Arun District Council
Arun Civic Centre
Maltravers Road
Littlehampton
West Sussex BN17 5LF
Planning & Building Control General Enquiries
Tel: (01903) 737756 Fax: (01903) 730442
Dx: 57406 Littlehampton
Minicom: 01903 732765
e-mail: planning@arun.gov.uk
website: www.arun.gov.uk/planning

Application No: FP/224/20/HH
Site Address: 57 Minton Road Felpham PO22 7JX
Description of works: Two storey side and rear extensions to existing dwelling & replacement of existing front loggia.

Thank you for your internet representation made on 23rd December 2020 which has been recorded as an objection with the comments as follows:

DRAWING
**ELEVATIONS
PROPOSED**
DRAWING No
323/05
REVISION
SCALE 1:100
DATE OCT 2020
DRAWN LA
CHECKED

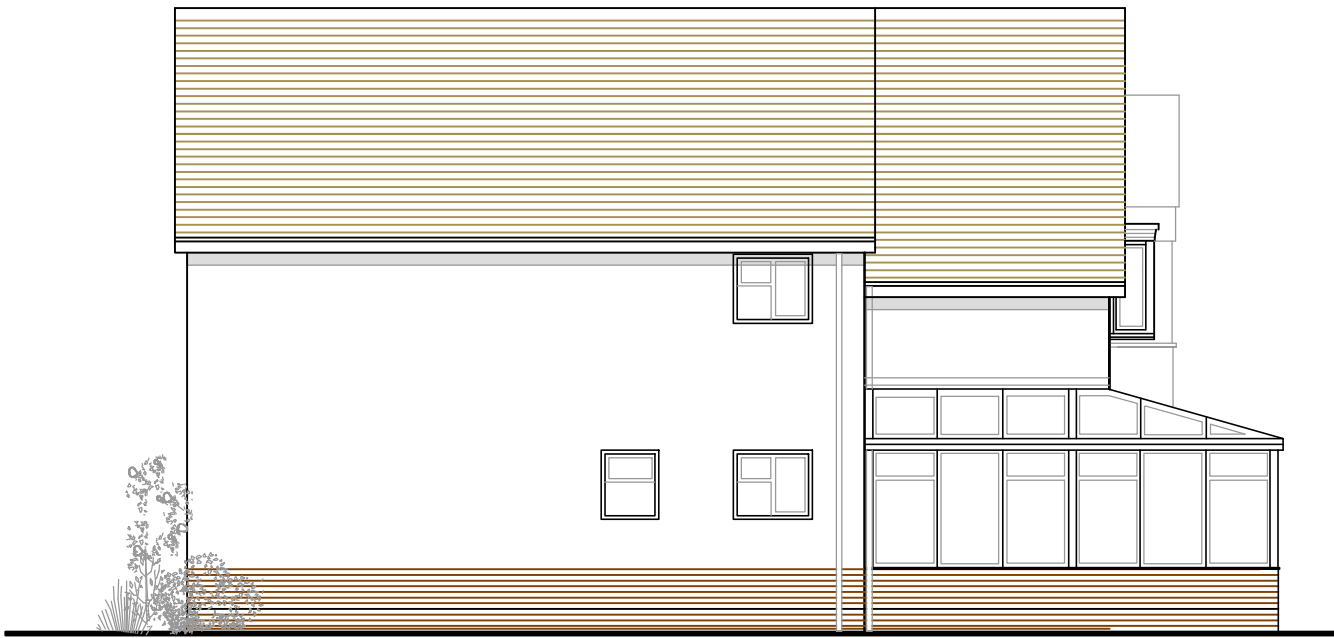
This is going to cause a significant loss of evening sunlight and daylight in general to the next door neighbours. Too big and too close. Surely it can be offset to the west where there is more room?
